April 23, 2015

This is a comment on the application of James Cherberg to construct a dock at 9418 SE 33rd Street, Mercer Island, WA. The Project Numbers are SHL 14-031 and SEP 14-025.

PROPOSED PIER

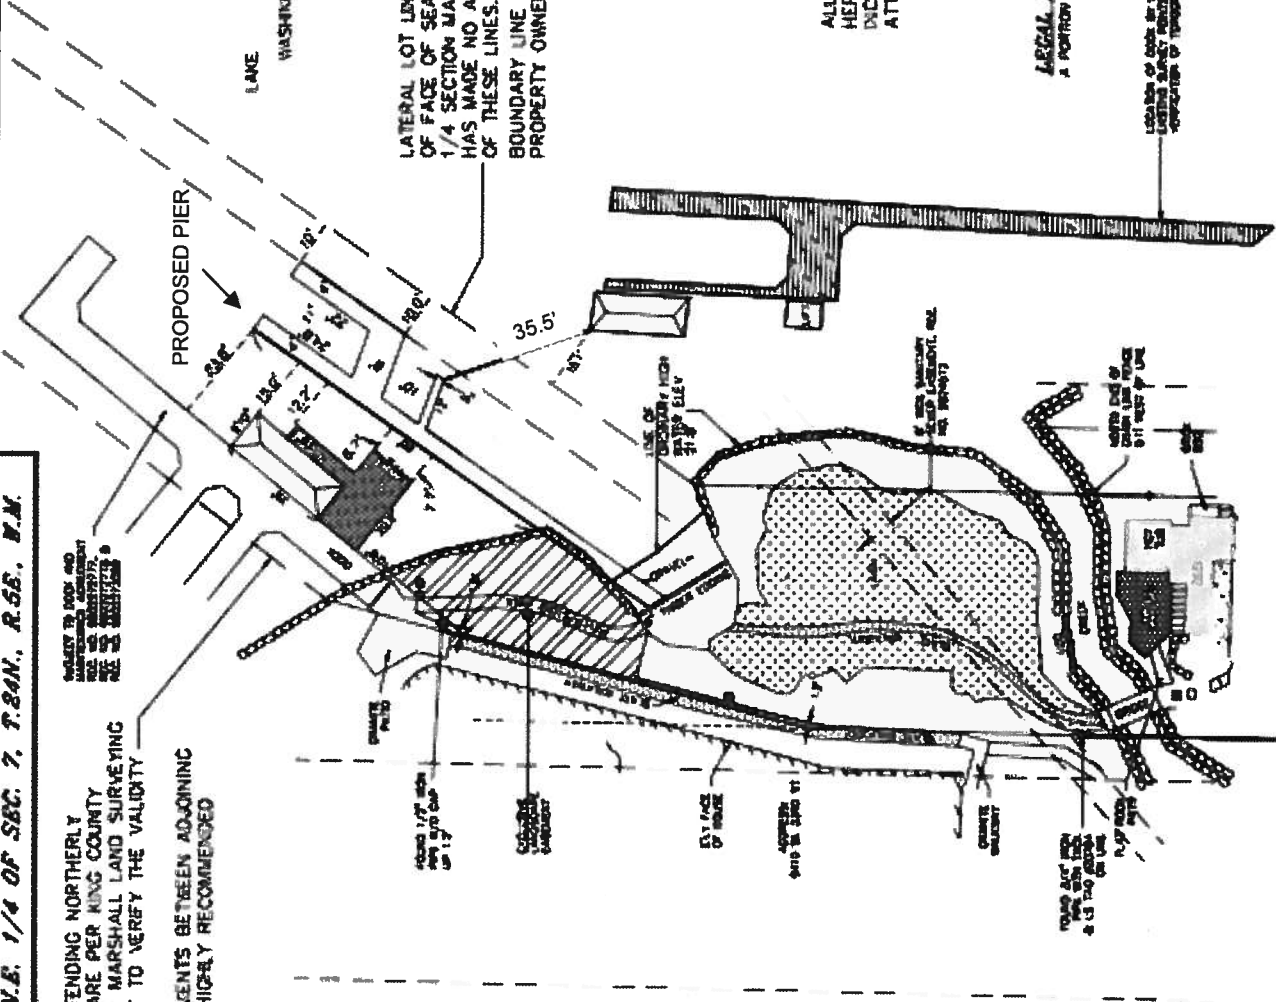
We have supported the Cherbergs' goal of obtaining a dock, so long as it is in scale and does not unreasonably limit the use of our dock. The proposal that has been filed, unfortunately, is out of scale for the small amount of waterway in that area. In addition, due to its size and configuration, the proposed dock would come very close (approximately 6 feet) to our existing dock and boat lift. The proposed Cherberg dock would be so close that it would make a significant part of our dock unusable. In addition, the dock would be so long that it would block use of the mooring area on the southeast side of our dock.

In short, the dock as proposed by the Cherbergs severely impacts the use of our own dock, is out of proportion to the available space and is far beyond any installation that we have ever contemplated. We believe, however, that a dock of suitable size and configuration can meet all reasonable requirements of the Cherbergs. We have expended effort, time and money to generate what we believe is a fair solution.

We previously proposed an alternative dock configuration for the Cherbergs' consideration. A copy is attached to this letter. The alternative proposal would provide a dock large enough to moor a large powerboat with a boatlift, to moor a wave runner with a lift, and to have adequate space for a diving board. It would not severely impact the use of our dock. Although it is not ideal from our family's perspective, in the spirit of neighborly cooperation, we would agree that it would serve as a basis for entering into an Adjacent Dock Use
